Rezoning Transportation Analysis

Petition Number: #2022-057

Date	Description
09-29-22	First Review (PDM)
10-27-22	Second Review (TM)
11-30-22	Second Review (DR)

TECHNICAL DATA
 PETITION NUMBER 2022-057

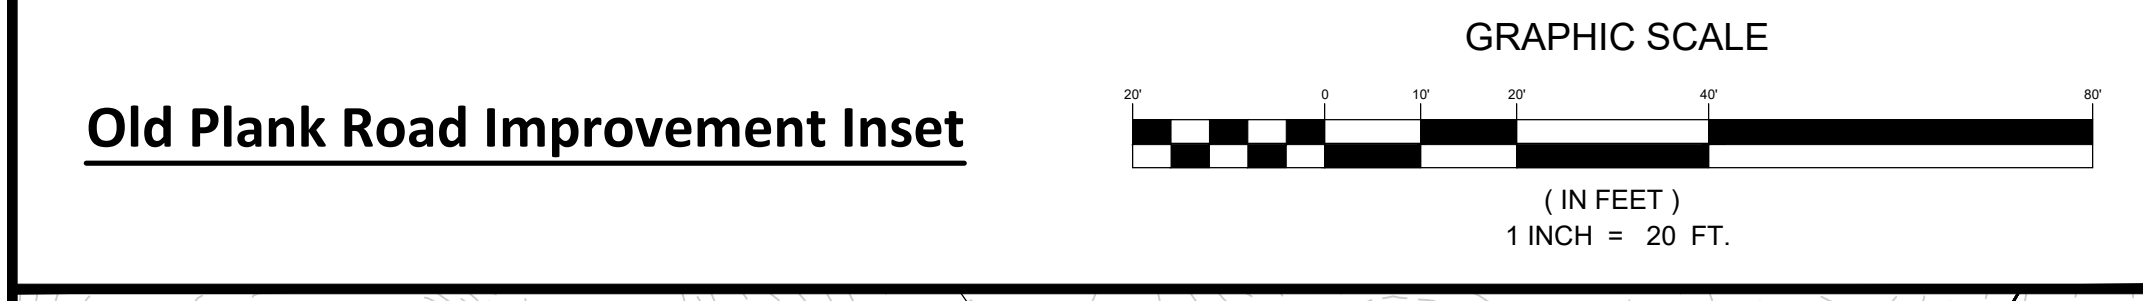
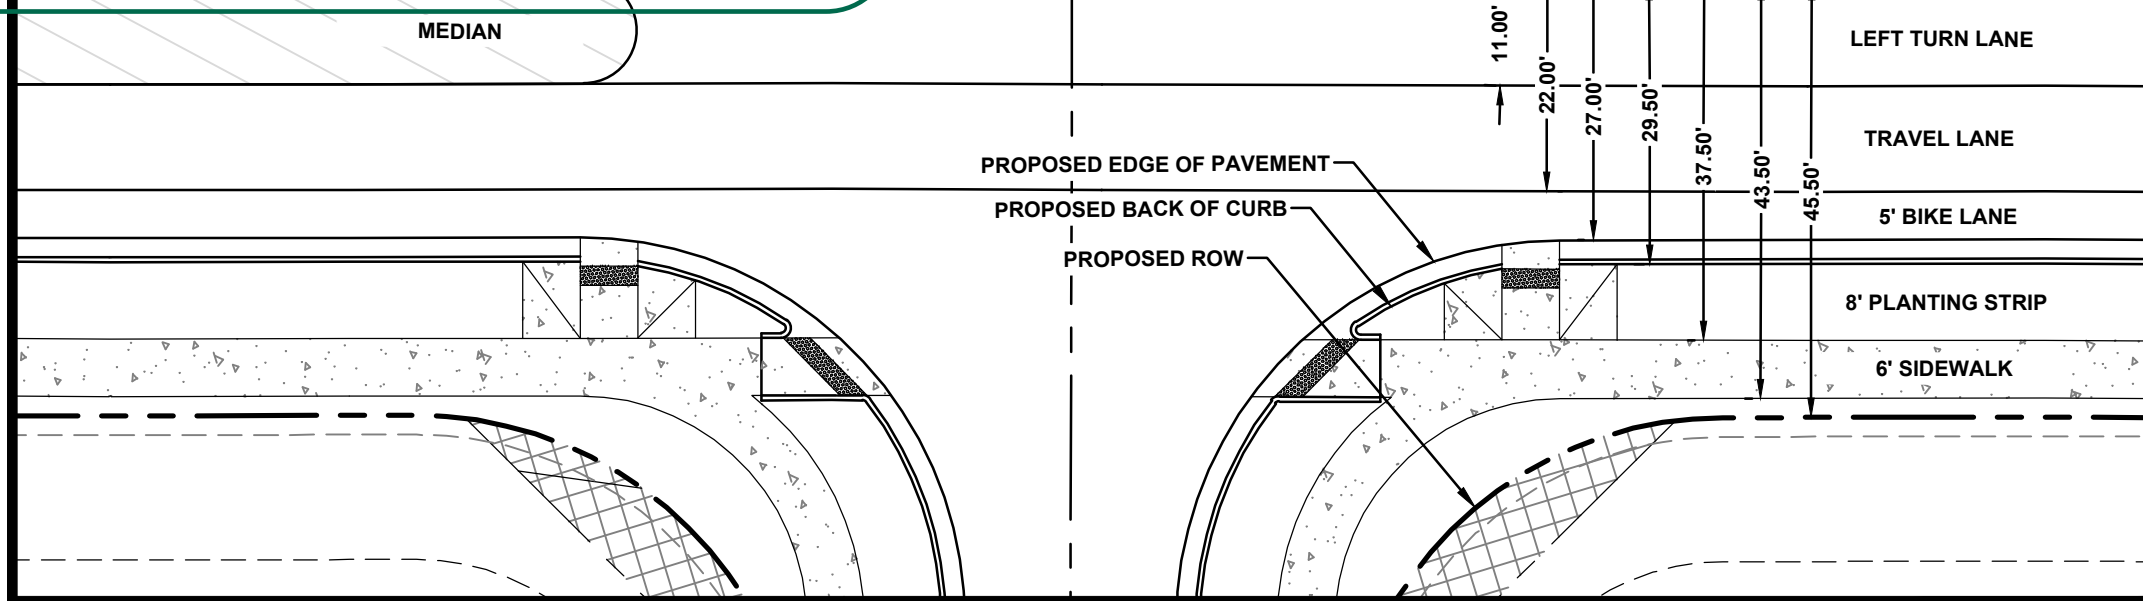
10. **Outstanding Comment From 9-29-22:** A site plan note specifying that all transportation improvements will be approved and constructed before the site's first building certificate of occupancy is issued as needed. The petitioner may phase transportation improvements if said improvements and phasing are explicitly described in site plan notes.

Remove Transportation Note 6 or clarify the full scope of the proposed phasing, including which improvements are proposed under each phase. Streetscape improvements to Old Plank Road, and the proposed access roads need to be constructed prior to the site's first building certificate of occupancy. The installation of the left turn lanes on Old Plank Road could be phased if desired.

Remove or clarify the proposed phasing.

Clarifying Comment From 11-30-22: Streetscape improvements to Old Plank Road and the proposed access roads need to be constructed prior to the site's first building certificate of occupancy.

Old Plank Road Improvement Inset

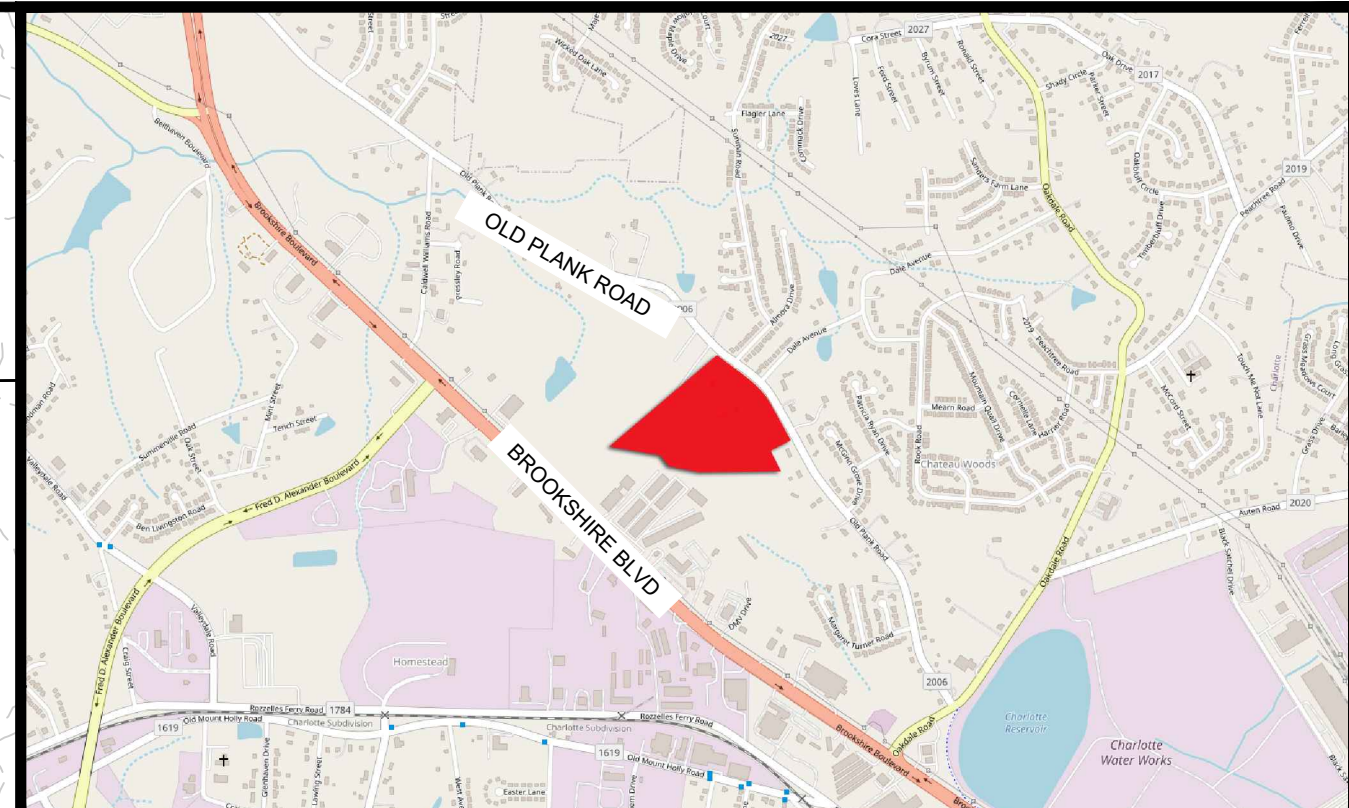
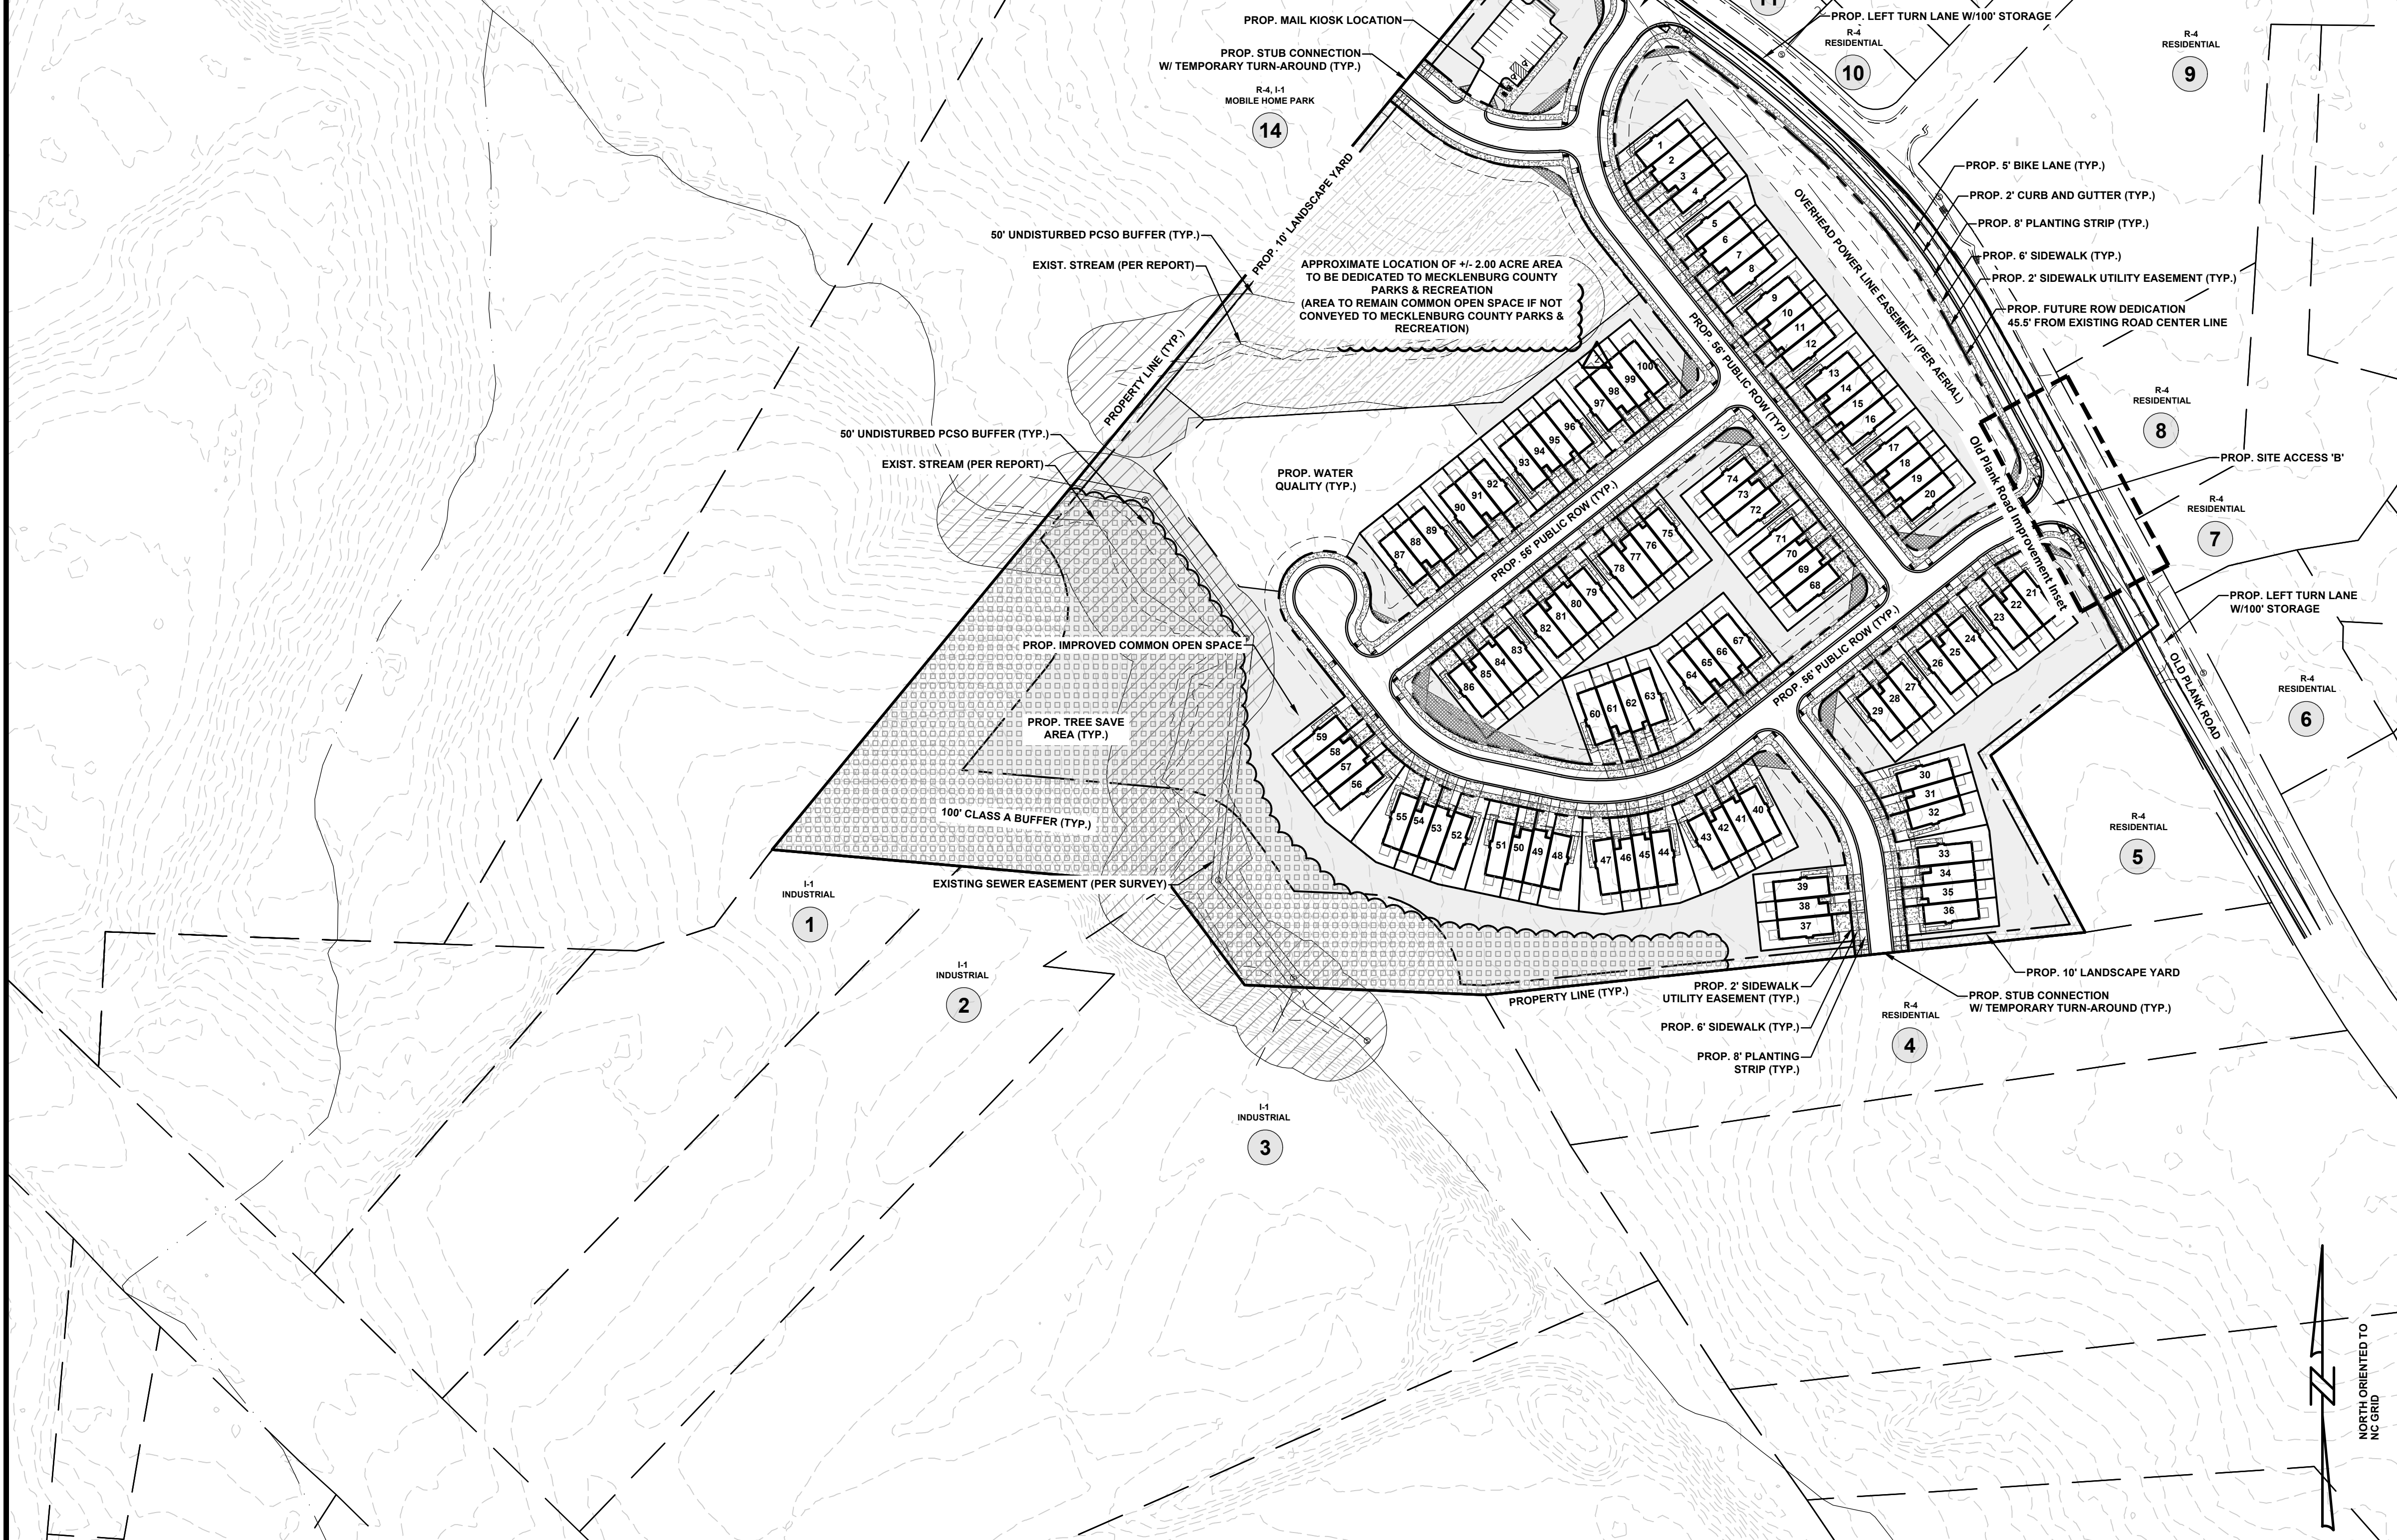
- a. ~~Old Plank Road:~~ Future location of the back of curb and gutter is 24 feet from the centerline of the roadway to the back of curb.

Resolved: Outstanding Comment From 9-29-22: Label and dimension the curb and gutter from the centerline for Old Plank Road on the site plan.

5. ~~Revise site plan and conditional note(s) to commit to construct bicycle facilities along site frontage by locating the curb and gutter 24 feet from the center line and installing a 5-foot bike lane along Old Plank Road to meet the City Charlotte BIKE Policy.~~

~~Resolved: Clarifying Comment From 10-26-22: Dimension back of curb from the roadway centerline.~~
